Fire Marshal Division

Re: Little Miracles Daycare

Application Numbers – BCOM1809-0002

PROJECT:
 INTERIOR ALTERATION & CHANGE
 OF OCCUPANCY
 TREE OF KNOWLEDGE DAYCARE CENTER
 622 BUFFALO LAKE ROAD
 SANFORD, NC 27332

1 FIRE ALARM PLAN  
FA-1 Scale: 3/16"=1'-0"

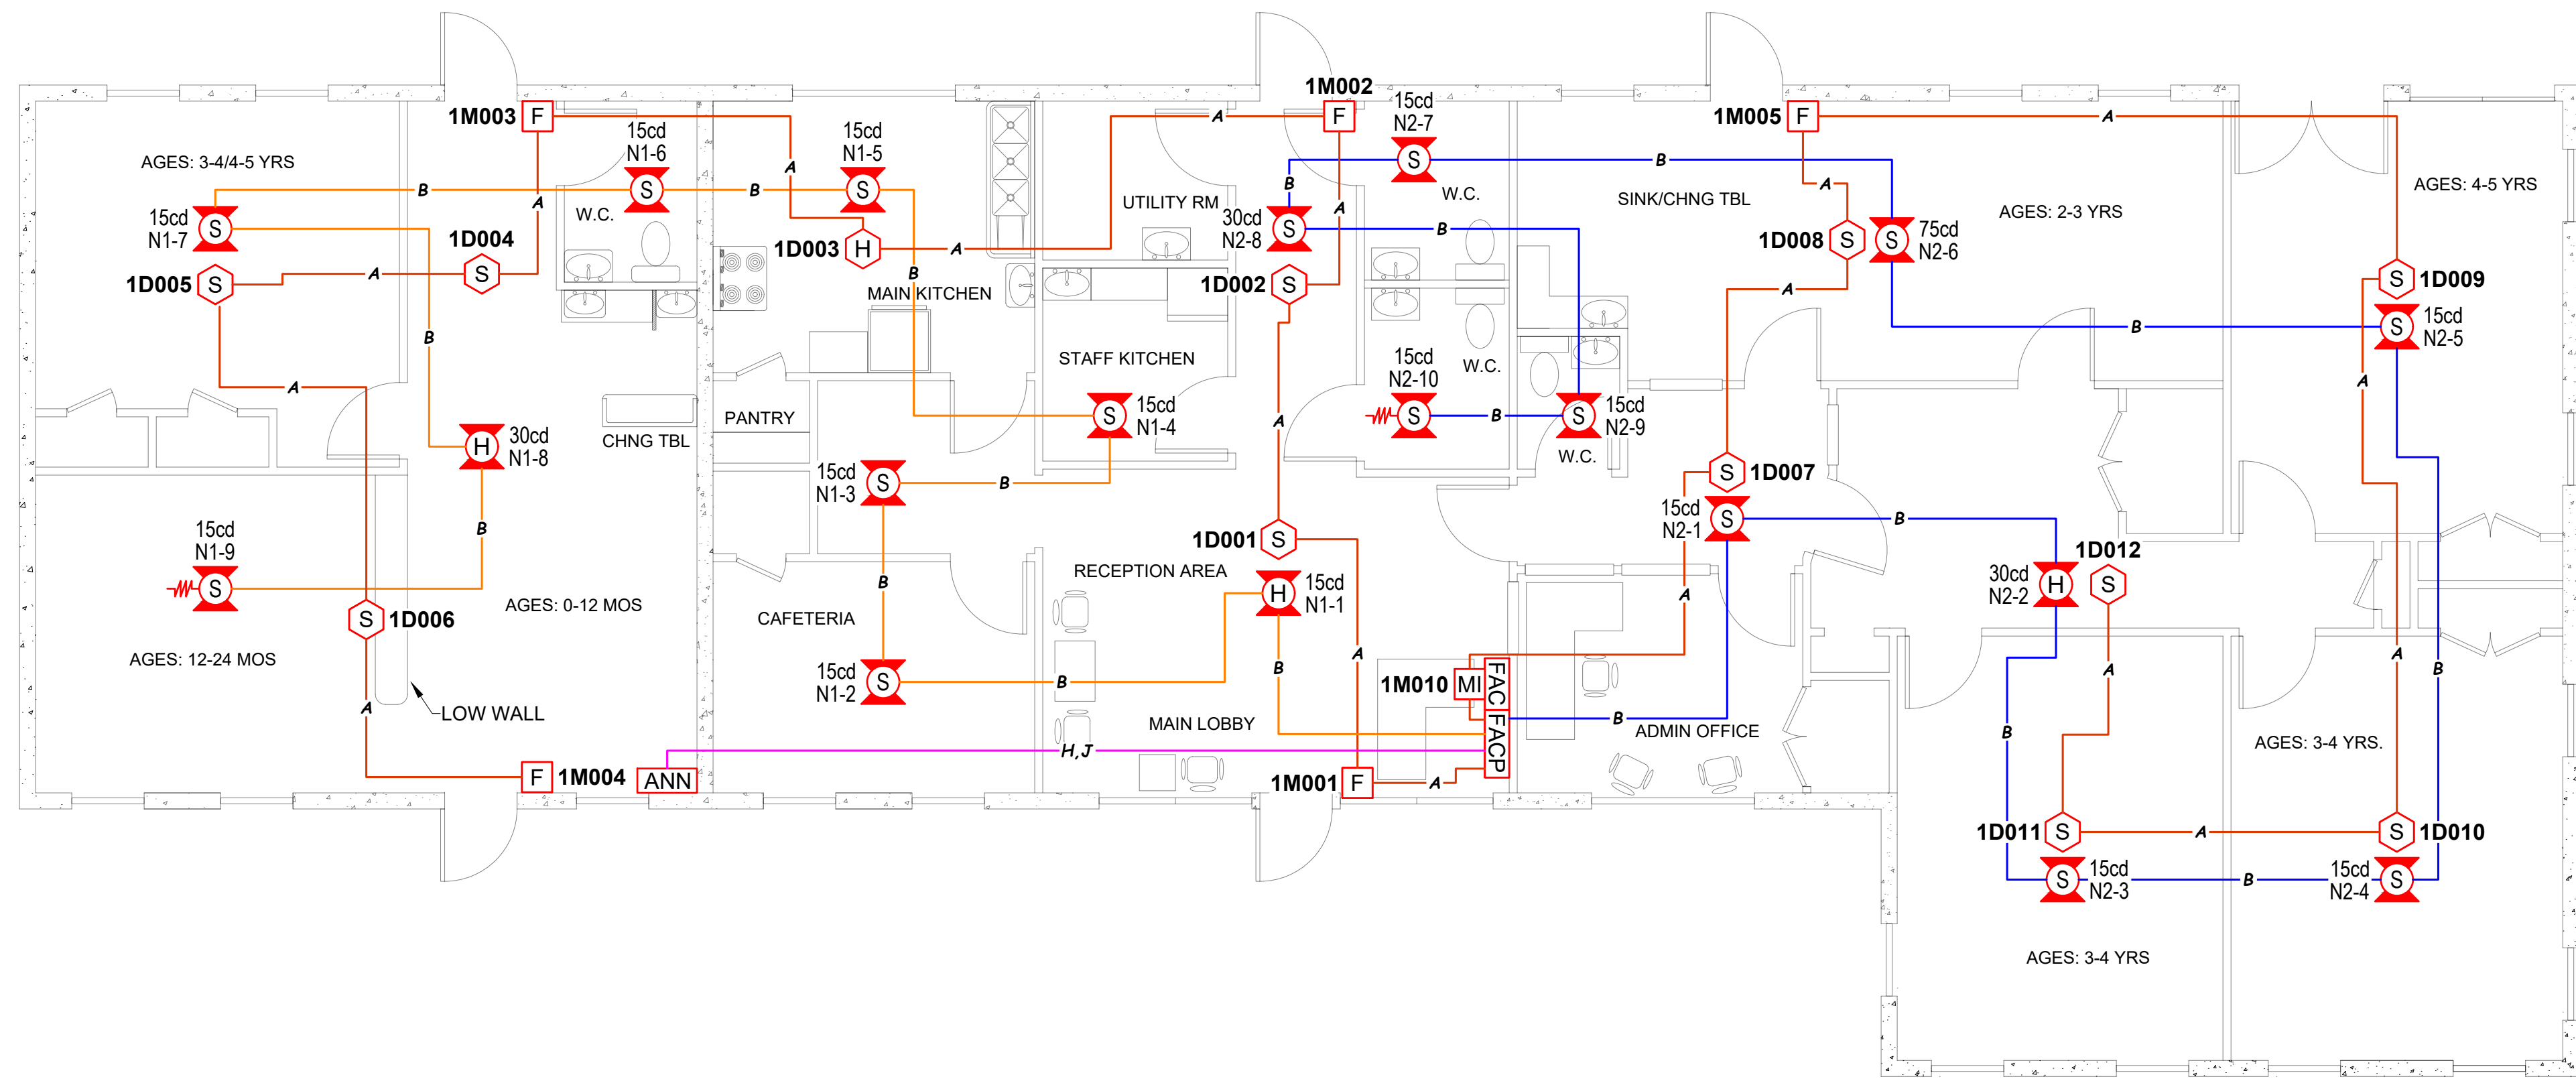
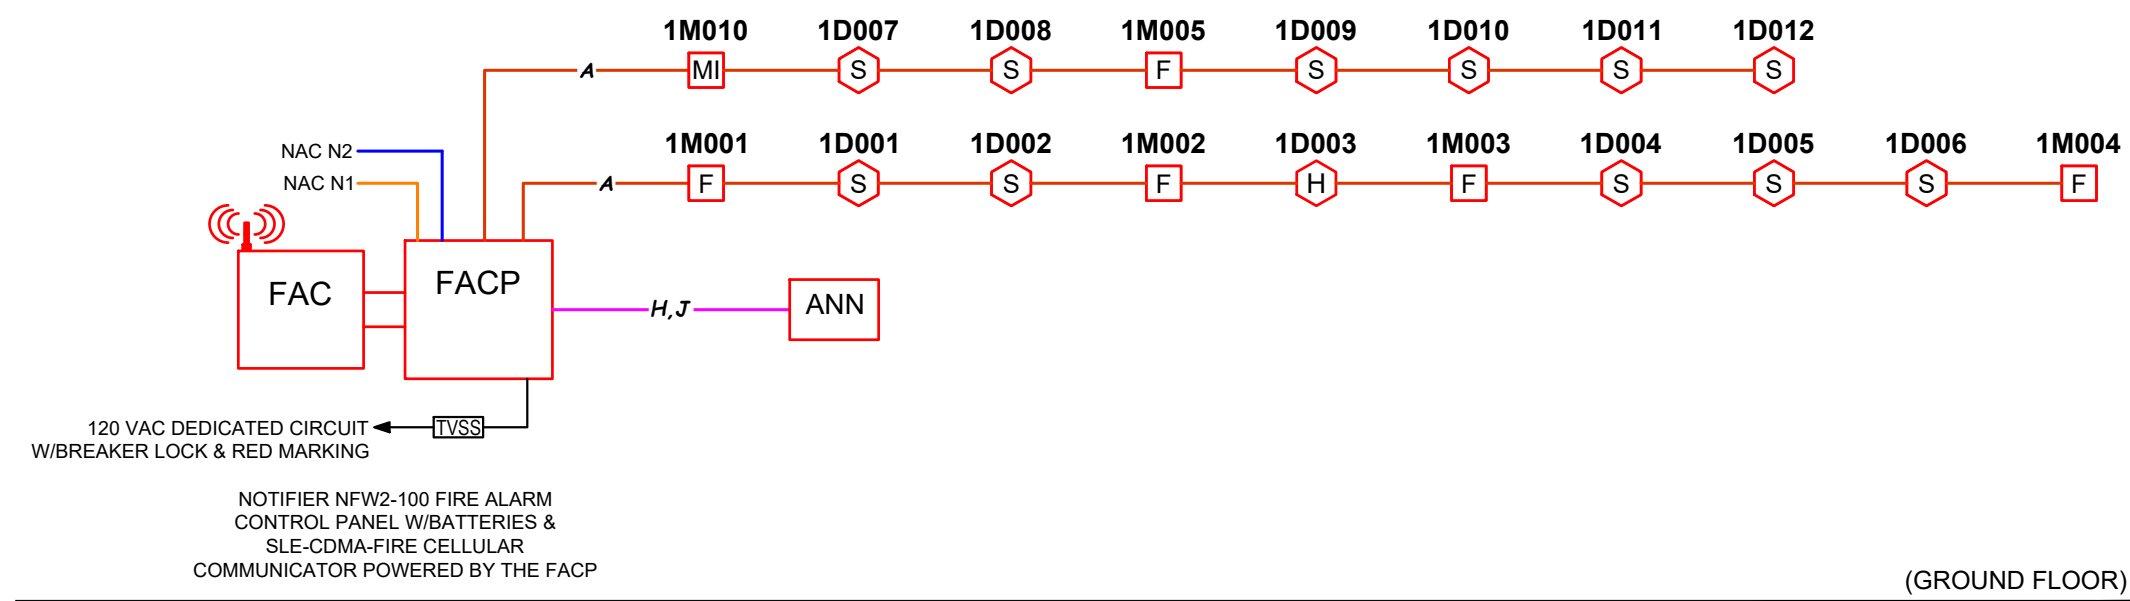
- **Fire Alarm System**
 - Fire alarm plans shall be submitted for review and approval.
 - The fire alarm system plans shall bear the seal of a licensed P.E. within the state of North Carolina.
 - Spec Sheets shall be submitted for all fire alarm system devices.
 - Any changes to the fire alarm system shall bear the seal of approval of a P.E.
 - Pull stations required at exits from nursery.
- **1008.1.10 Panic Hardware**
 - Doors serving spaces in a Group E occupancy with 49 > persons must be provided with panic hardware and listed in accordance with UL 305.
- **Notes**
 - **Please provide fire extinguisher locations, FACP location, smoke detector locations**
 - **See note on drawing referencing door swing reversal**
 - **Please schedule all fire inspections with the Fire Marshal's Office.**
 - **910-984-4003**

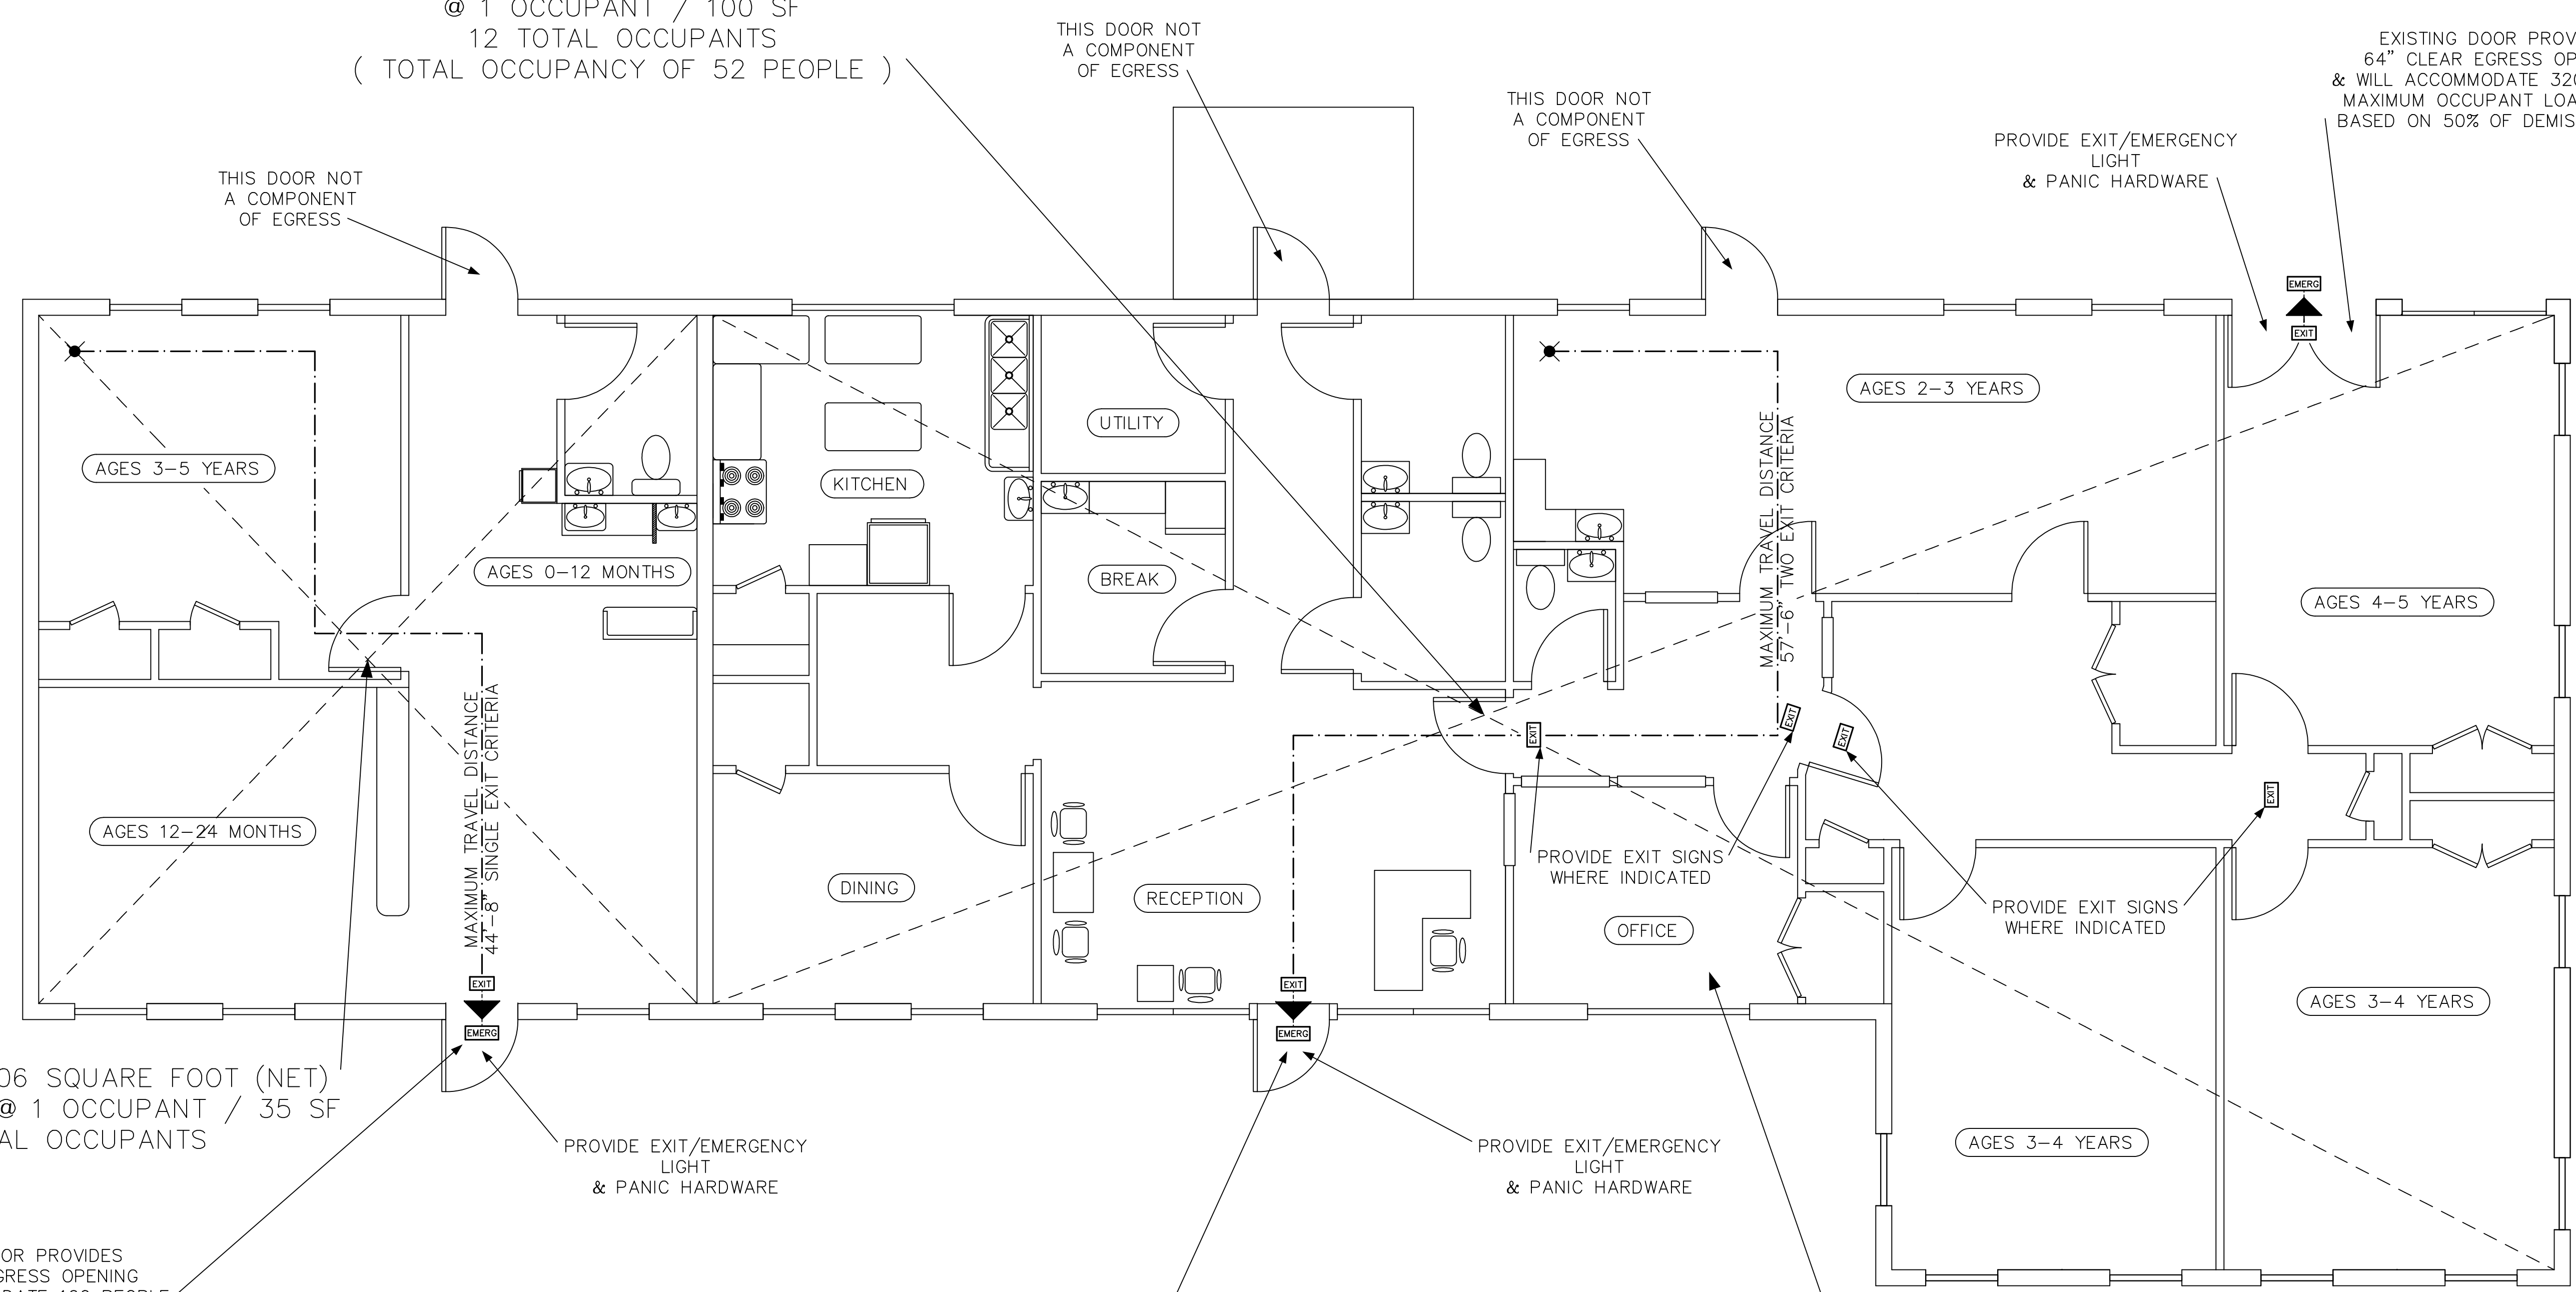
- **1003.2.11 Means of egress illumination.**
 - The means of egress, **including the exit discharge**, shall be illuminated at all times the building space served by the means of egress is occupied
 - The portion of the exterior exit discharge immediately adjacent to exit discharge doorways in buildings required to have two or more exits.

- **906.1 Fire Extinguishers**
 - Fire extinguishers shall be located as not to exceed 75' of travel distance to an extinguisher.
 - The fire extinguishers provided shall have a minimum rating of 2A10:BC and shall not be installed higher than 5 feet above the finished floor.
